Your ref:		Please reply to:	Fraser Fikrie
Our ref:	21/07365/P3JPA	Tel No:	0753424 7967
		Fee Queries:	0207 641 6500;
		Email:	planningreception@westminster.gov.uk;
Mr Robert Greenwood Vital Energi Century House, Roman Road Blackburn, Lancashire BB1 2LD		Incomplete Applications Development Planning City of Westminster PO Box 732 Redhill, RH1 9FL	
		28 October 2021

Address: St Stephens Nursery, 42 Westbourne Park Road, London, W2 5PH,

Proposal: Installation of 42.1m2 roof mounted photovoltaic array(s) and associated infrastructure at Dementia & Memory Resource Centre, 42 Westbourne Park Road,, London W2 5PH

Thank you for your application received on 27 October 2021. I am writing to inform you that your application is incomplete for the following reason(s):

Project: WESTMINSTER CITY COUNCIL REFIT					
Title: DEMENTIA AND MEMORY CENTRE					
SOLAR PANEL ROOF SECTION					
DATE	23.09.2021	SCALE	NTS	SHEET	A3

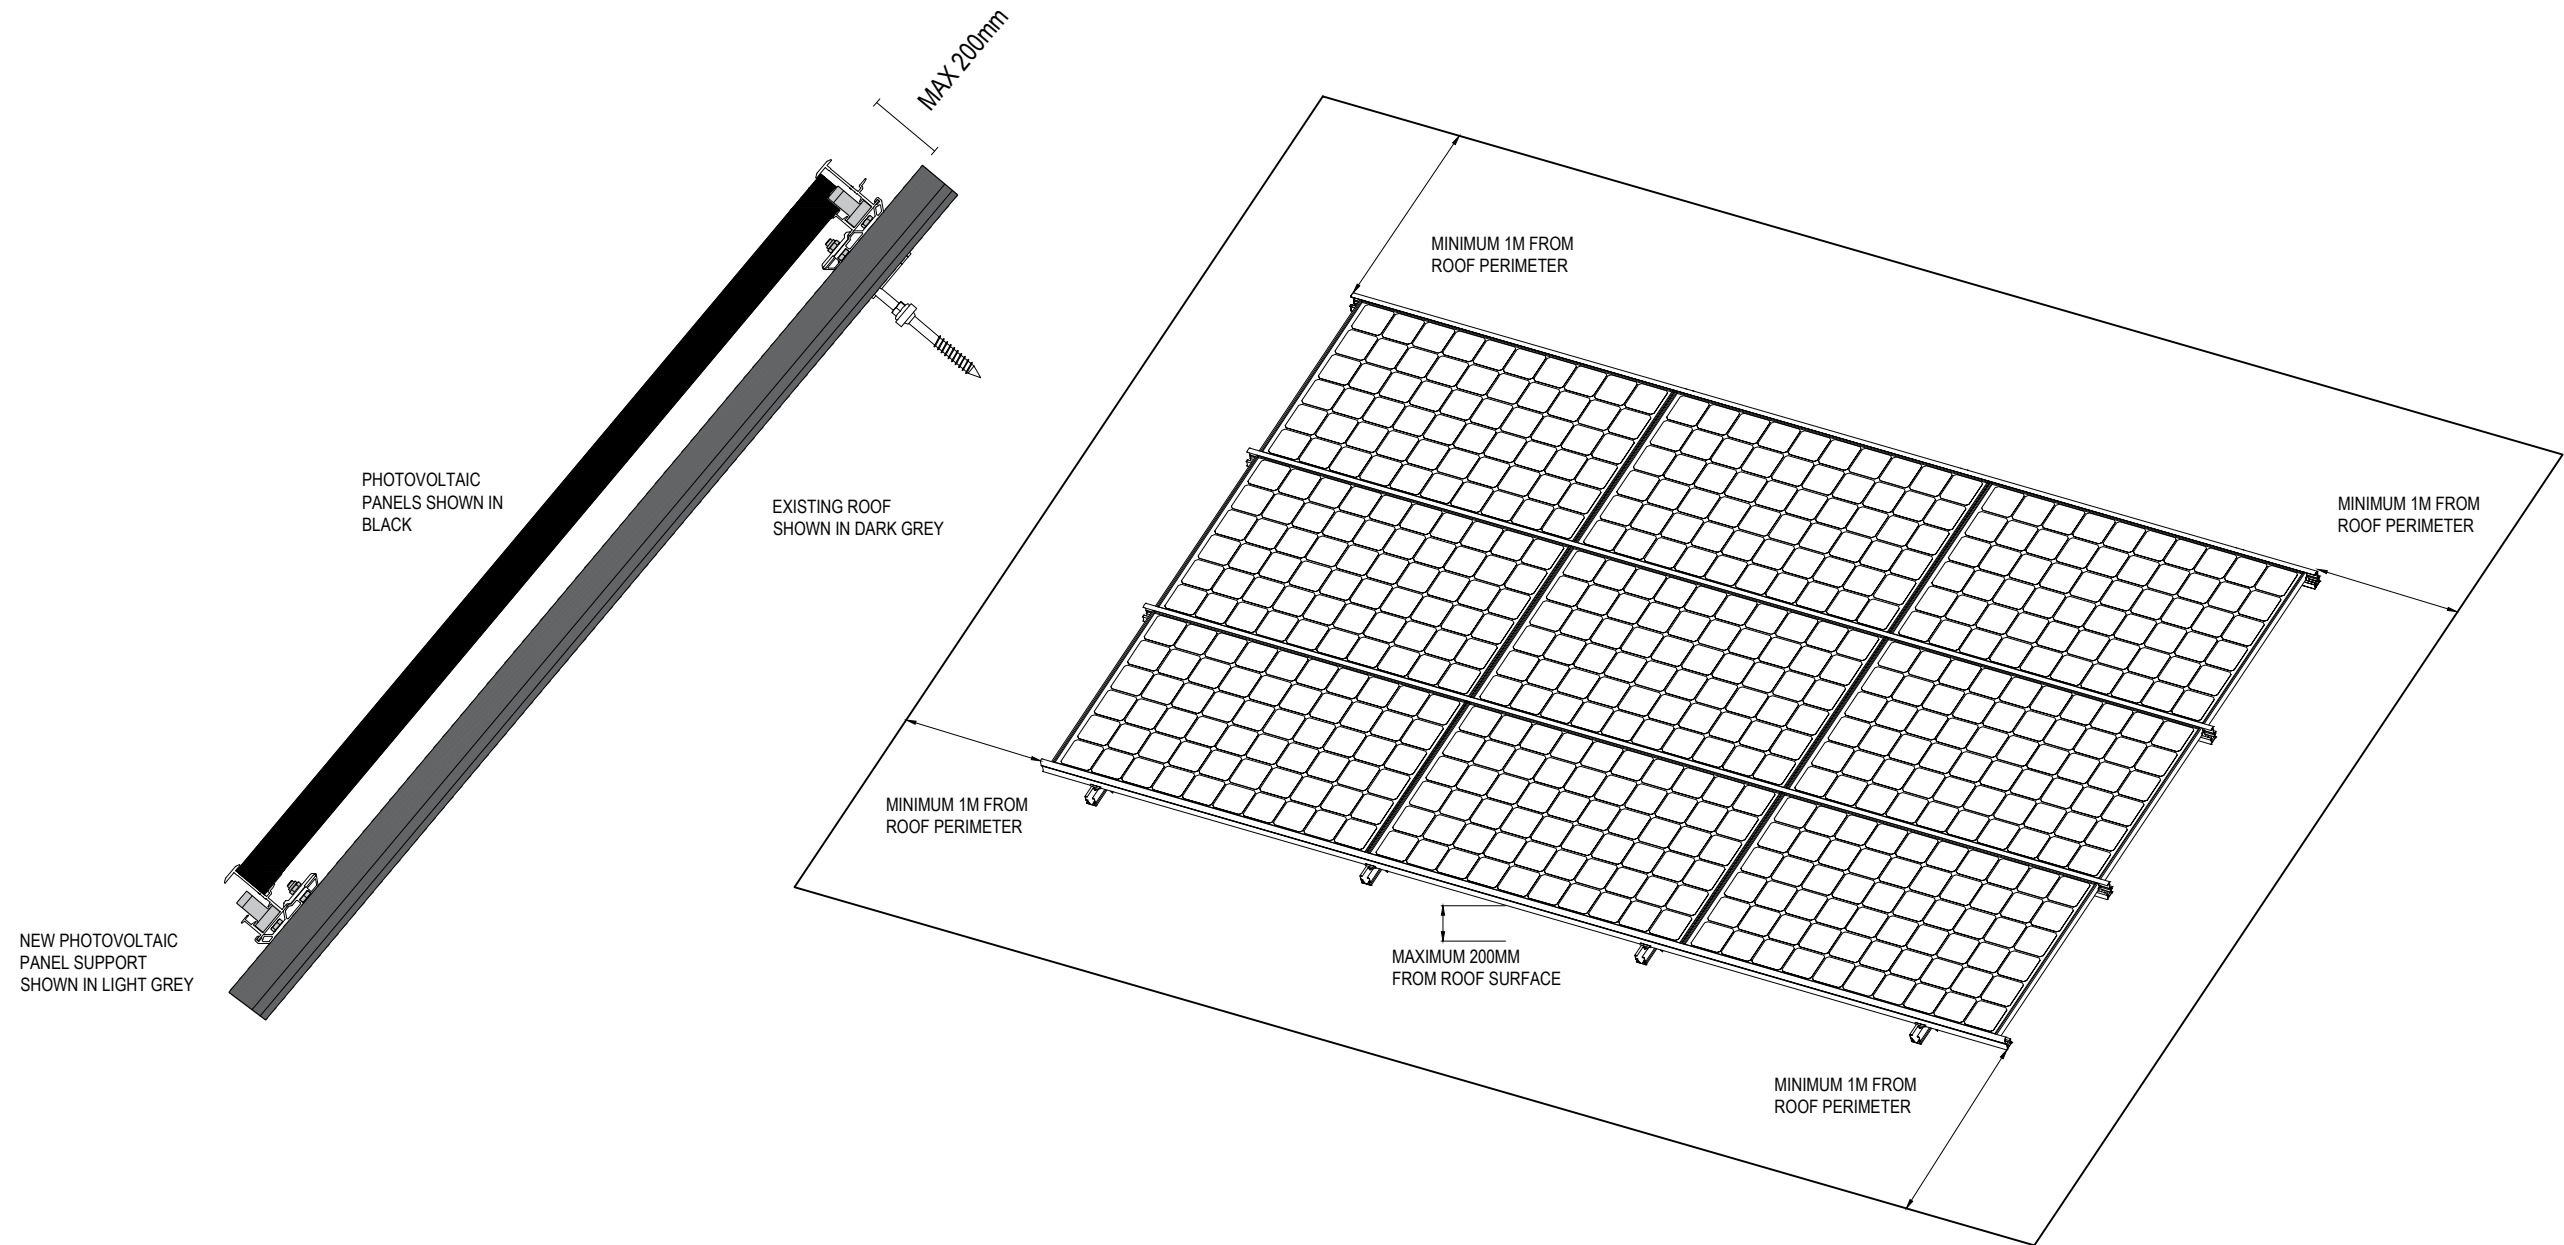
- 1 Your drawing are not labelled as either existing or proposed and we also require elevations as well as existing roof plans. Please provide:
 - existing roof plan with correct labelling
 - proposed roof plan with correct labelling
 - existing and proposed elevations of the building in context to the proposed photovoltaic.
